From: Brenda Larsen
Sent: Friday, April 11, 2014 9:13 AM
To: Kaycee Hathaway
Subject: RE: Kittitas County Notice to Agencies BL-14-00007 Mynar
Attachments: Myner-Revised.doc

Re: Myner (BL-14-00007)

After conducting a review of the recent changes to the above named project, I have the following comments:

PROPOSED

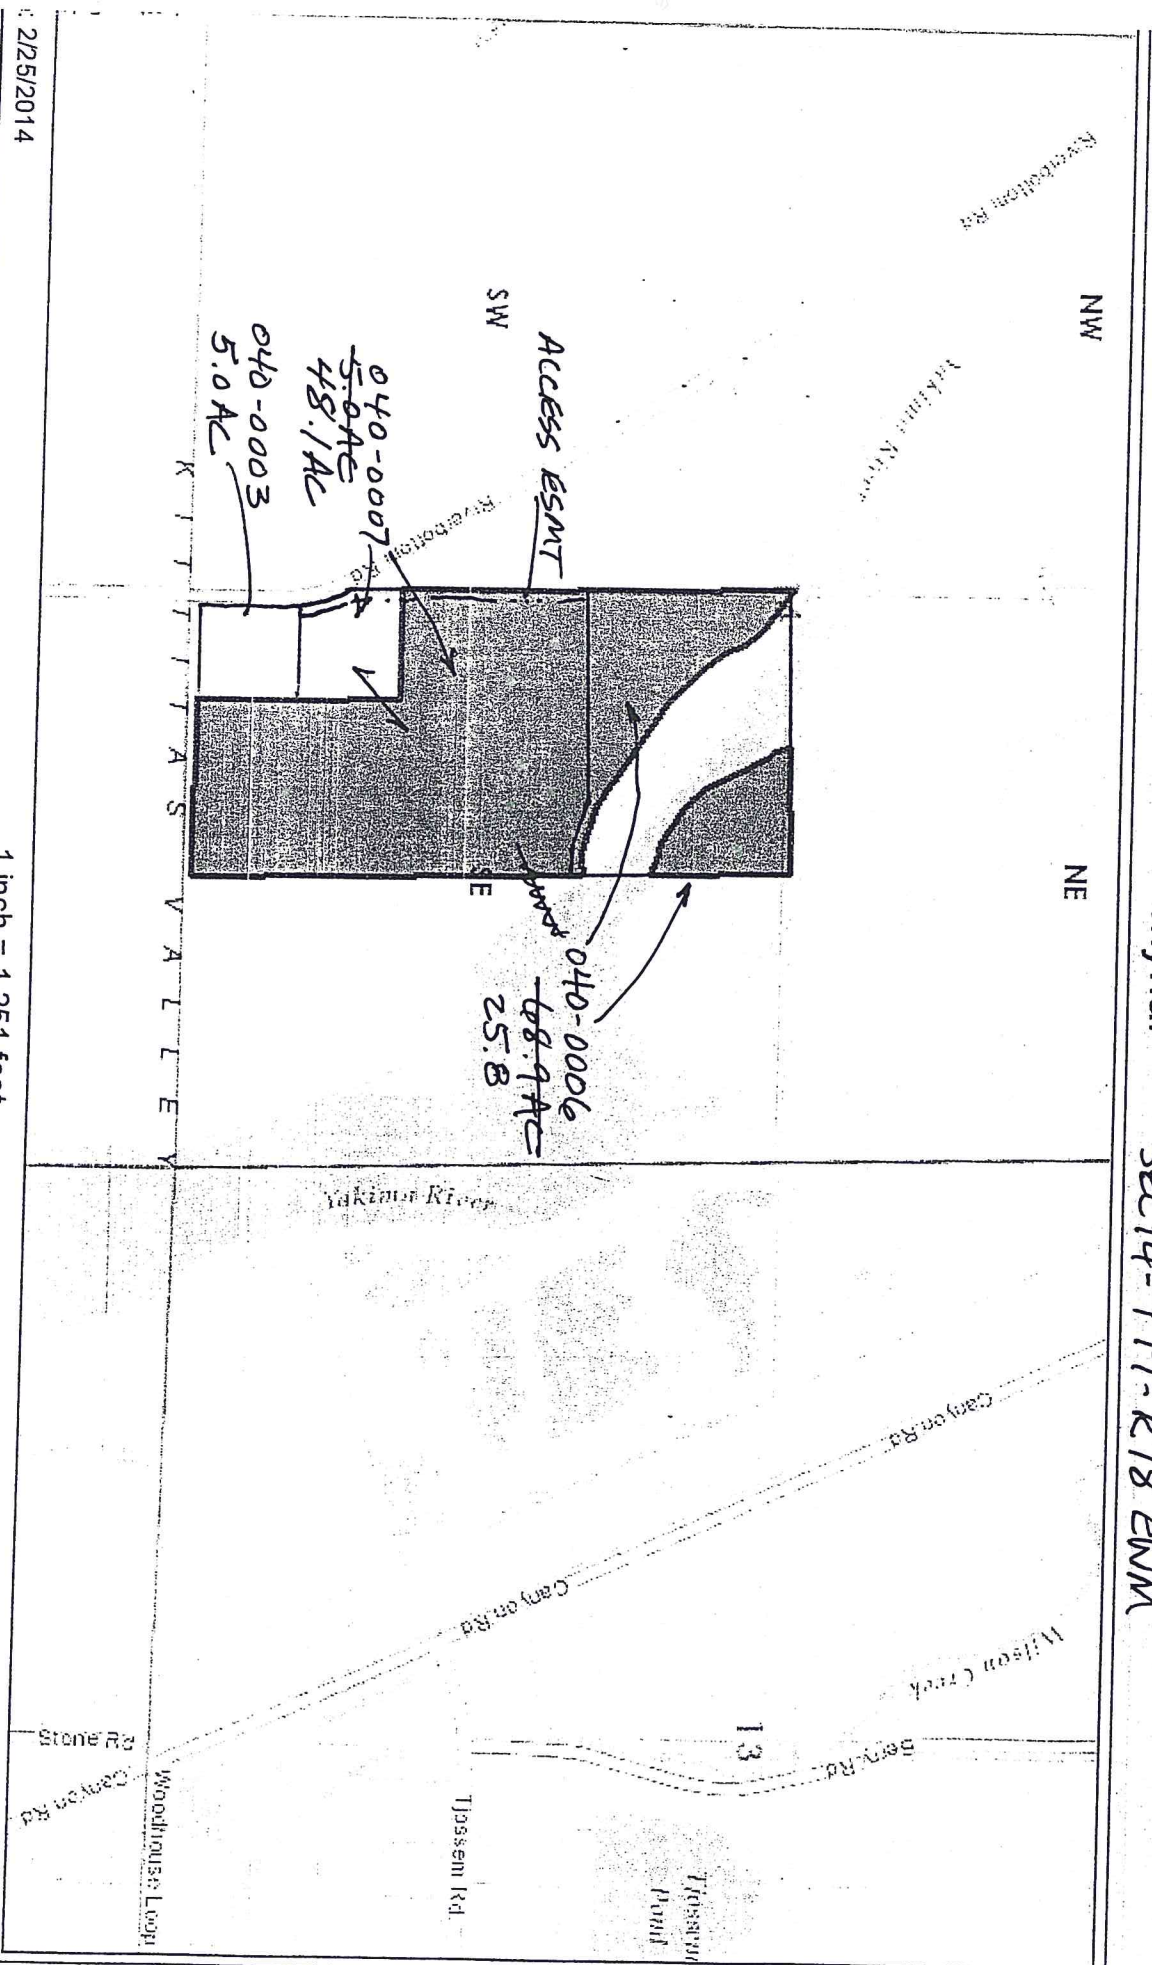
- Ensure that boundary line adjustments do not infringe upon existing structures, to include propane tanks, etc.
- Ensure adequate access for fire apparatus. Any driveways or access points created based off the new lot configurations shall comply with Kittitas County Code 20.02.030.
- All future development must comply with the International Fire Code.
